**KIRKLEES METROPOLITAN COUNCIL
INVESTMENT & REGENERATION SERVICE**

DELEGATED DECISION TO DETERMINE PLANNING APPLICATIONS

Reference No:	2024/62/90958/E
Site Address:	587, Bradford Road, Oakenshaw, Bradford, BD12 7EJ
Description:	Erection of detached outbuilding for incidental use
Recommending Officer:	Nina Sayers

DECISION - REFUSED

PLANNING BY DESIGN FROM CONCEPT TO COMPLETION ALL DIMENSIONS TO BE VERIFIED ON SITE THIS DRAWING IS NOT FOR CONSTRUCTION	Rev	587 Bradford Road BD12 7EJ	OUTBUILDING PLAN AND ROOF PLAN		
			Date	28.02.2024	Scale @ A3
			By	JL	1:100
			Drwg ref:	587BradfordRoadOutbuildingPlanAndRoofPlanV2	
			No.	14

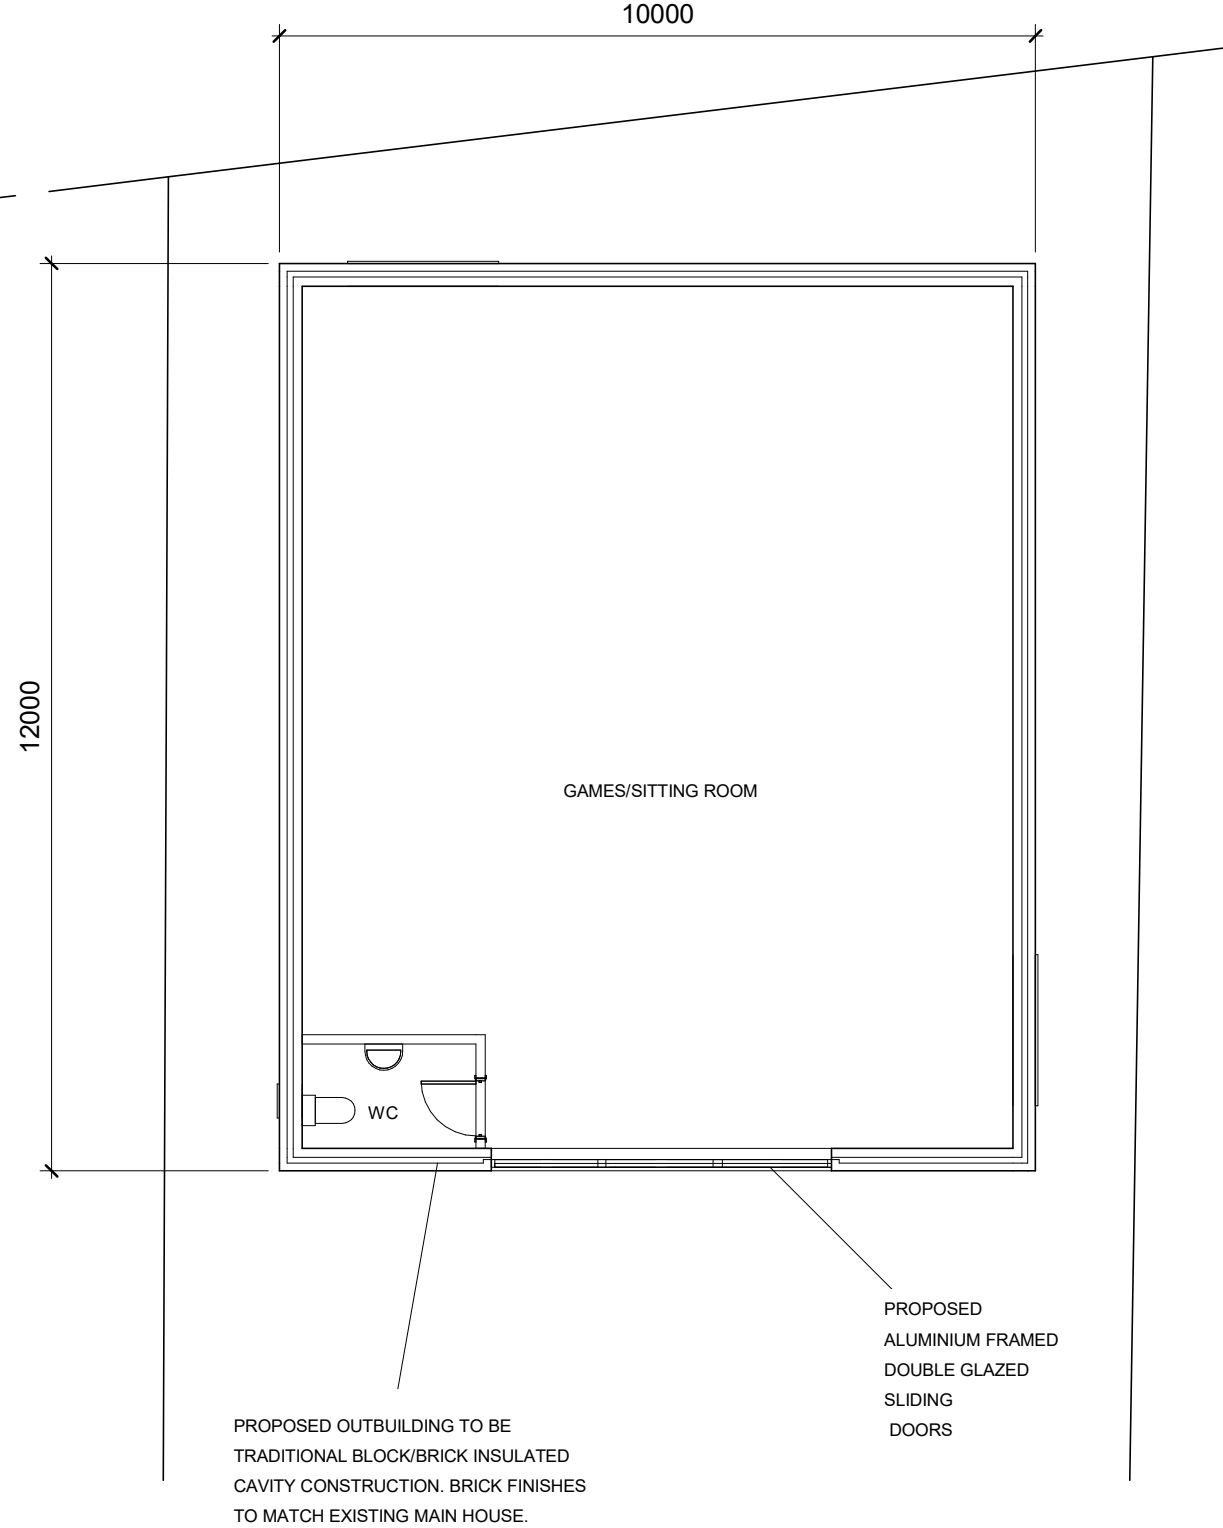
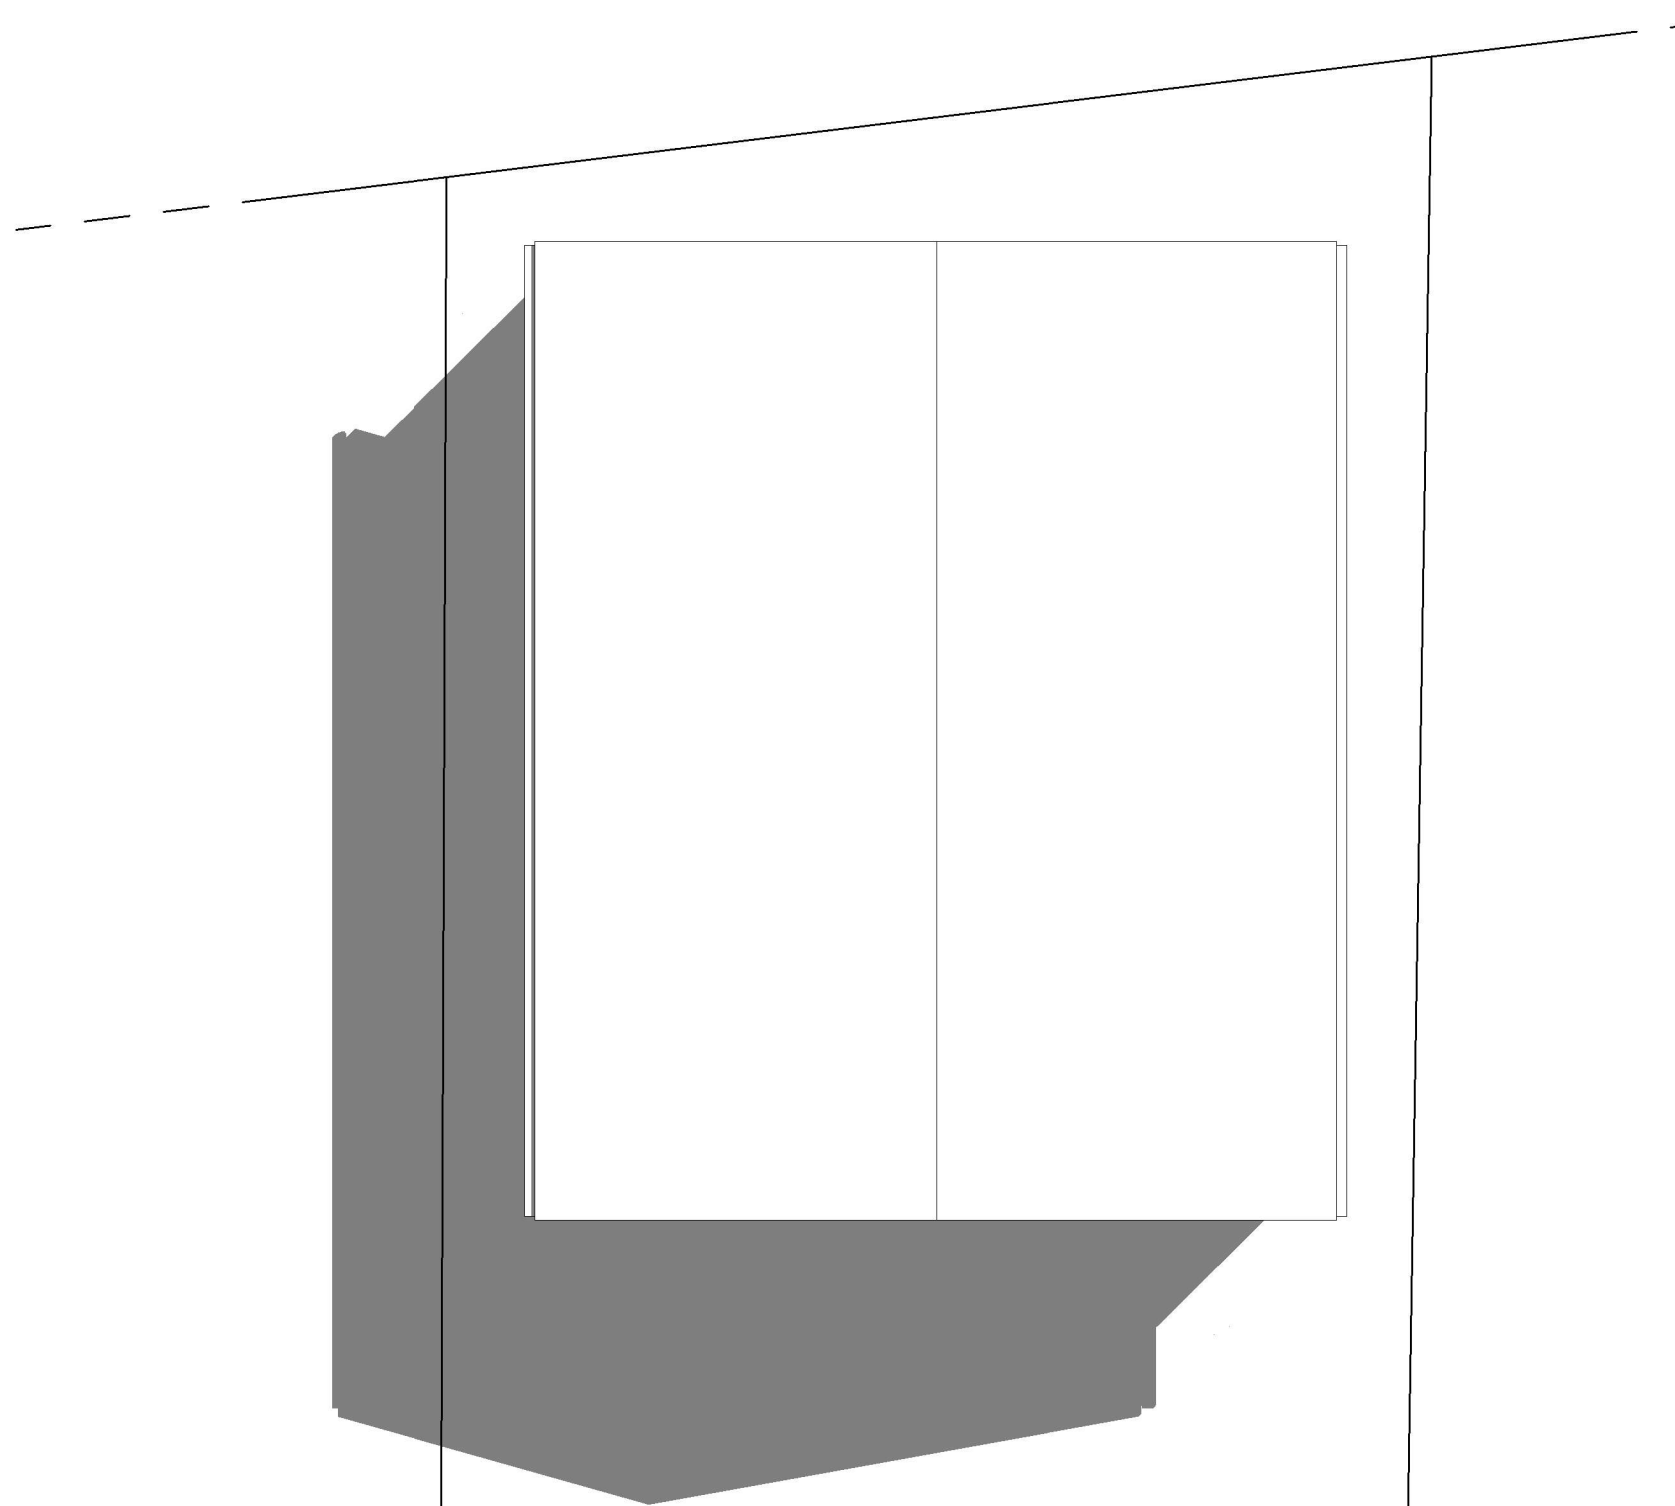
The proposed outbuilding would be located in the most westerly point of the application site, at the end of the garden area. It would be 12m deep and 10m wide with a pitched roof design measuring 3.8m to the eaves. It would be finished in brick to match the existing house.

The proposed outbuilding would be large in scale with a volume of ~372m³. It is noted that the existing outbuilding would be demolished as part of the proposal.

The proposed development would be a significant addition to the property which would cover a floor area 25% larger than the original dwelling. Although no volume calculations have been provided, officers have calculated that the proposal would result in a volume addition of approximately 46% when taking into consideration the demolition of the existing outbuilding. It would be a 62% addition if the existing outbuilding remains.

Although it is noted that the proposed outbuilding would be single storey, the scale and massing of the proposed development would be disproportionate to the host dwelling and thus would result in harm to the Green Belt land. This is without taking into account the live planning application for a single storey rear extension (2024/91534).

As outlined in the principle of development section of this report, the proposed outbuilding would be large in both footprint and volume and would result in a significant addition to the host dwelling, even when taking into consideration the demolition of the existing outbuilding. This is without taking into account the live planning application for a single storey rear extension (2024/91534). The proposal is therefore not considered subservient to the original building and would result in a disproportionate addition to the host dwelling, at the detriment

Having taken the above into account, the scale of the proposed outbuilding would be disproportionate to the scale of the original building and would not be subservient to the host dwelling. This would be at the detriment to the visual amenity of the host dwelling and character of the Green Belt setting, failing to comply with Policy LP24 and LP57 of the Kirklees Local Plan, KDP 1 & 2 of the House Extension and Alterations SPD and the aims of chapter 12 and 13 of the National Planning Policy Framework.

1. The proposed development would compete in scale with the host building and amount to disproportionate additions over and above the size of the original building, resulting in a detrimental reduction in openness of the Green Belt constituting inappropriate development and harm to visual amenity of the host dwelling and character of the Green Belt. No very special circumstances have been submitted to clearly outweigh the harm caused by reason of inappropriateness or other harm. This is contrary to chapters 12 and 13 of the National Planning Policy Framework, together with part of policies LP24 and LP57 of the Kirklees Local Plan and the House Extensions and Alterations SPD.
